DELEGATED HOUSEHOLDER DECISION

Item No.	Report of the Head of Development Management and Building Control	
Address:	34 LEYBOURNE ROAD HILLINGDON	
Development:	Erection of a front porch, single storey rear and a double storey side extension. Conversion of roof space to habitable use to include a hip to gable end extension, rear dormer and front roof lights (amended description)	
LBH Ref Nos:	7946/APP/2024/98	
Drawing Nos:	S01 S02-A S03-A S04-A S05-A D01 D02 D03 D04 D05 D06 D07 D08	
Date Plans received:	15-01-24	Date(s) of Amendments(s):
Date Application valid	15-01-24

Drawing Title
PROPOSED SINGLE STOREY
REAR EXTENSION AND
LOFT CONVERSION

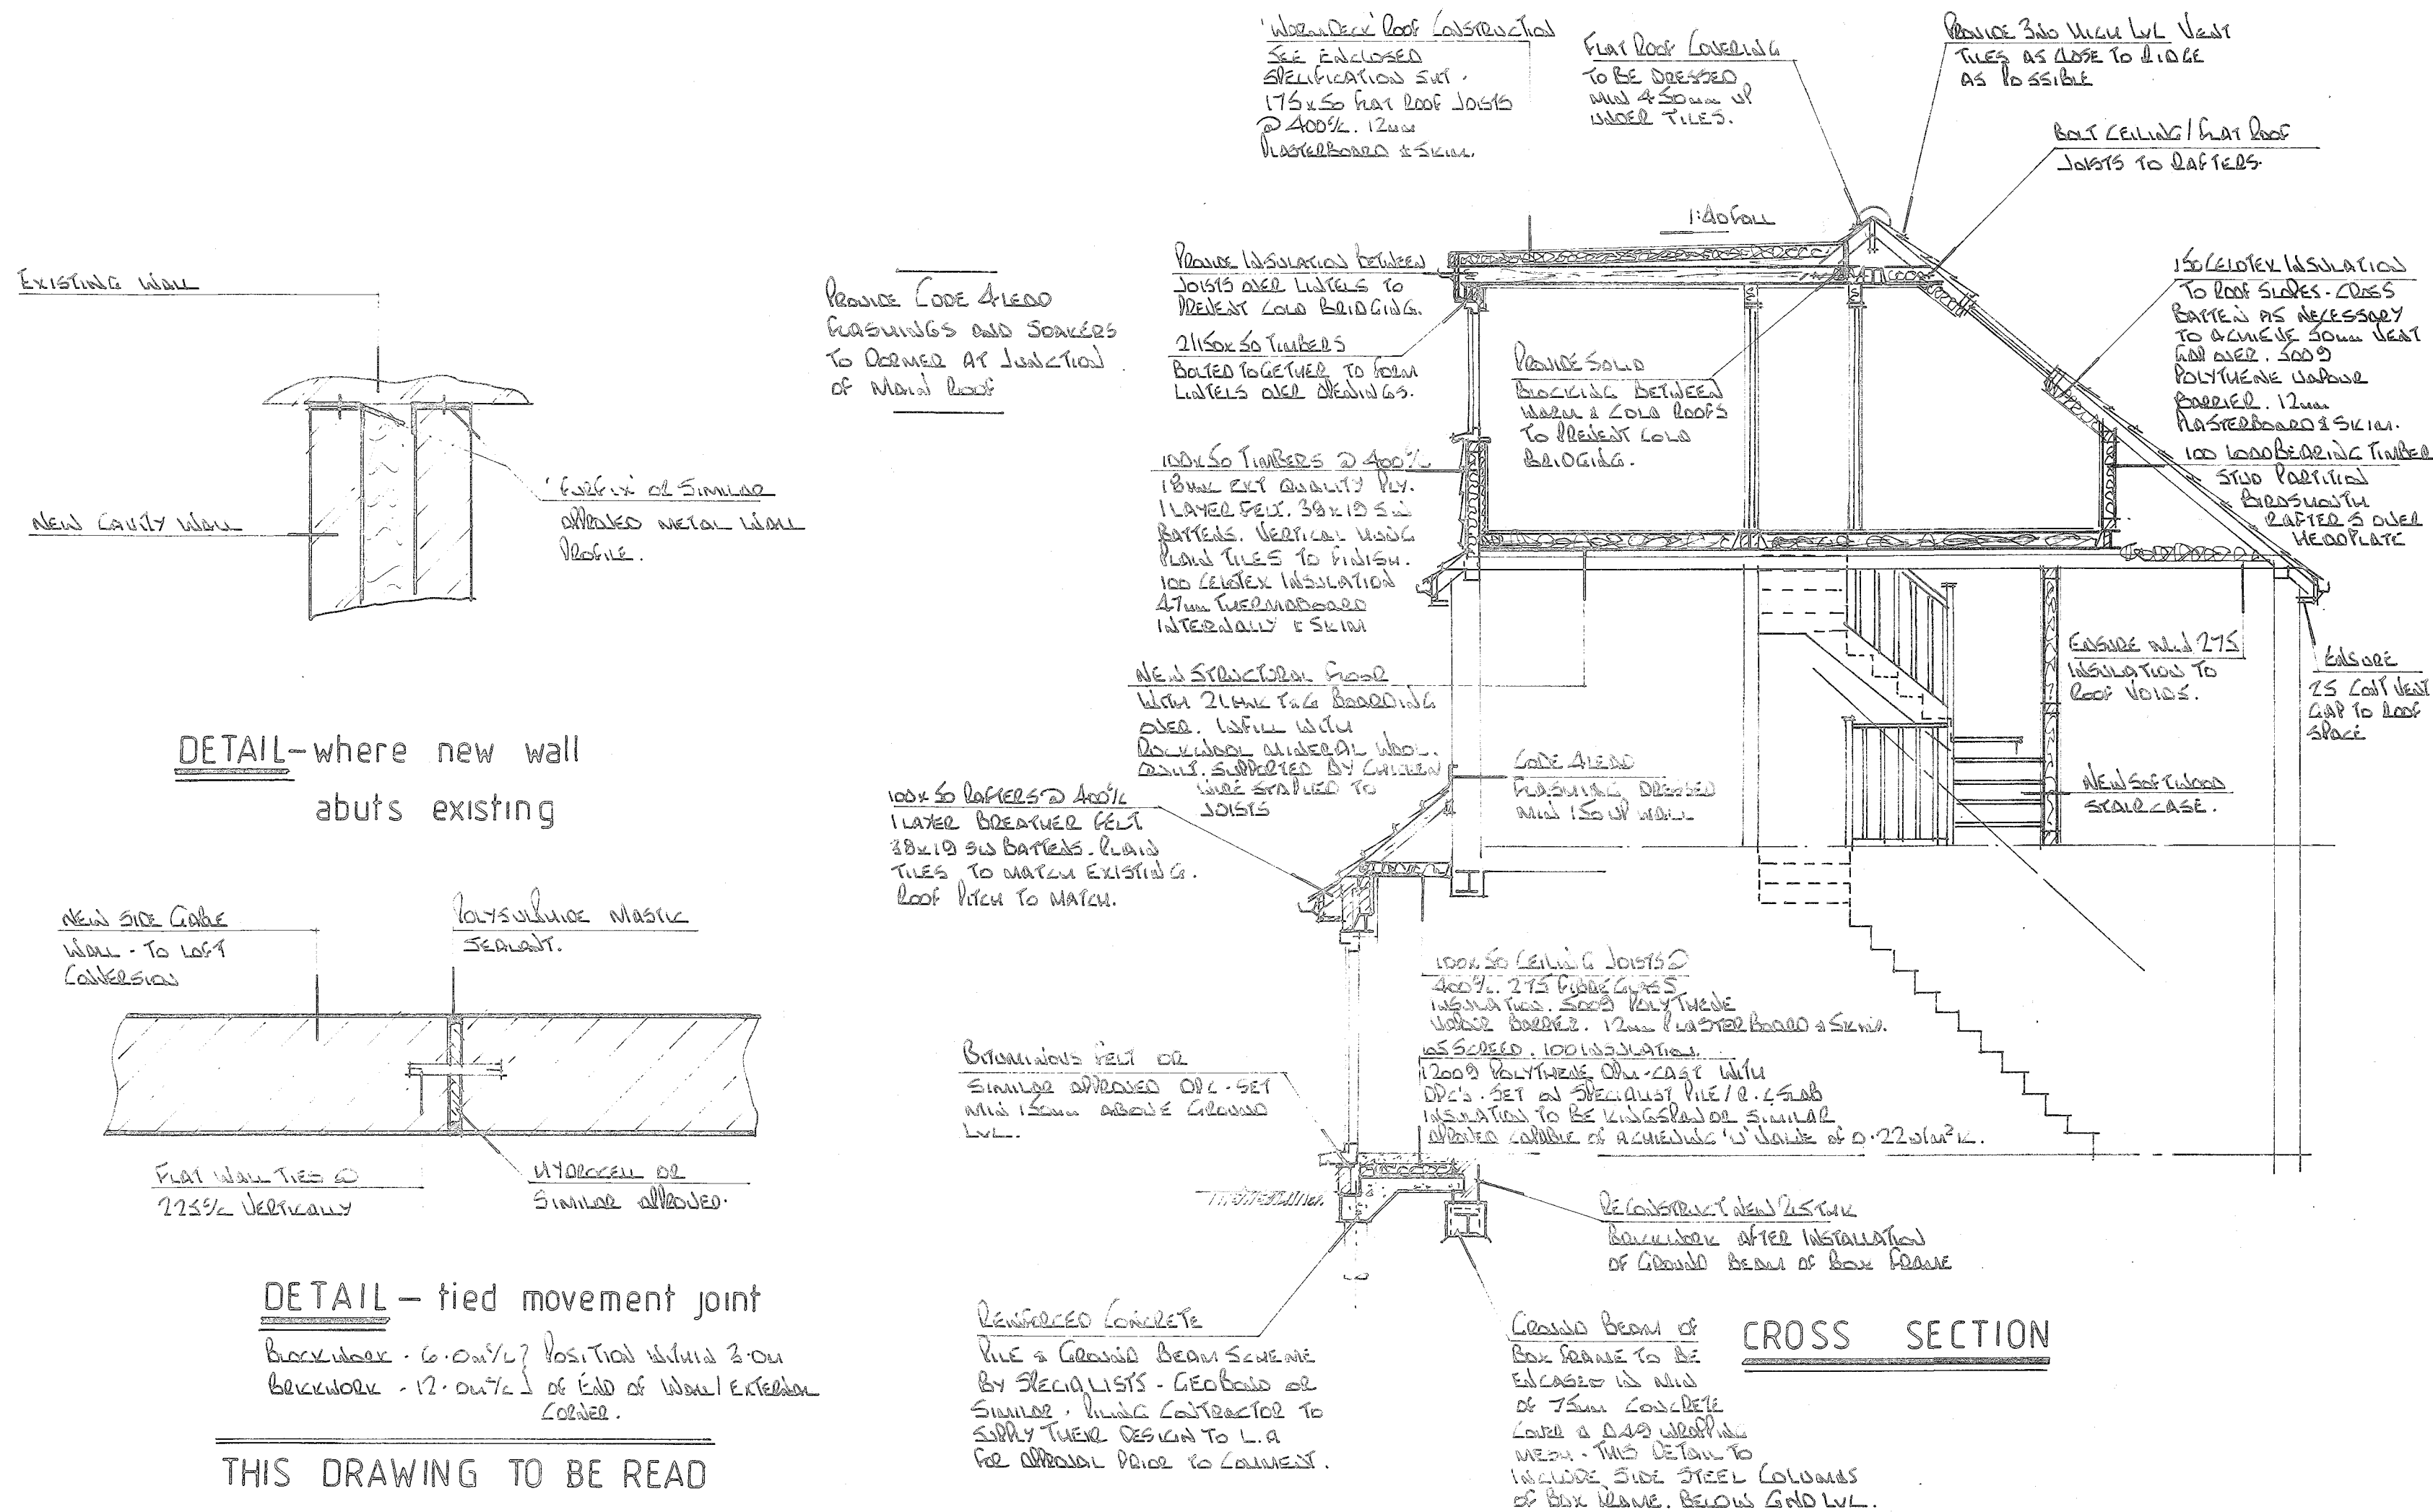
The proposed development would also include a double storey side extension and a hip to gable roof extension with rear dormer and front rooflights. It is noted that the site has extant permission for a double storey side extension and other works under reference 7946/APP/2023/2960 and a separate certificate of lawfulness for a hip to gable extension and rear dormer under reference 7946/APP/2021/4068. However, a double storey side extension and hip to gable extension are directly against Policy DMHD 1. The combination of these elements would form a disproportionate, overly large addition to the original dwelling, harming its architectural composition. It would appear overly dominant within the street scene and due to its prominent corner plot positioning would be readily available from multiple public vantage points.

The proposed development by reason of its combined hip to gable extension, double storey side extension and resultant roof form would be unduly prominent, visually incongruous and unsympathetic to the original architectural composition of the host dwelling, resulting in a detrimental impact on the character and appearance of the original dwelling and would be out of keeping with the character and appearance of the immediate street scene and surrounding area. The proposal thereby fails to comply with Policy BE1 of the Hillingdon Local Plan: Part One- Strategic Policies (November 2012), Policies DMHB 11, DMHB 12 and DMHD 1 of the Hillingdon Local Plan: Part Two - Development Management Policies (January 2020), Policies D3 and D4 of the London Plan (2021) and Chapter 12 of the National Planning Policy Framework (2023).
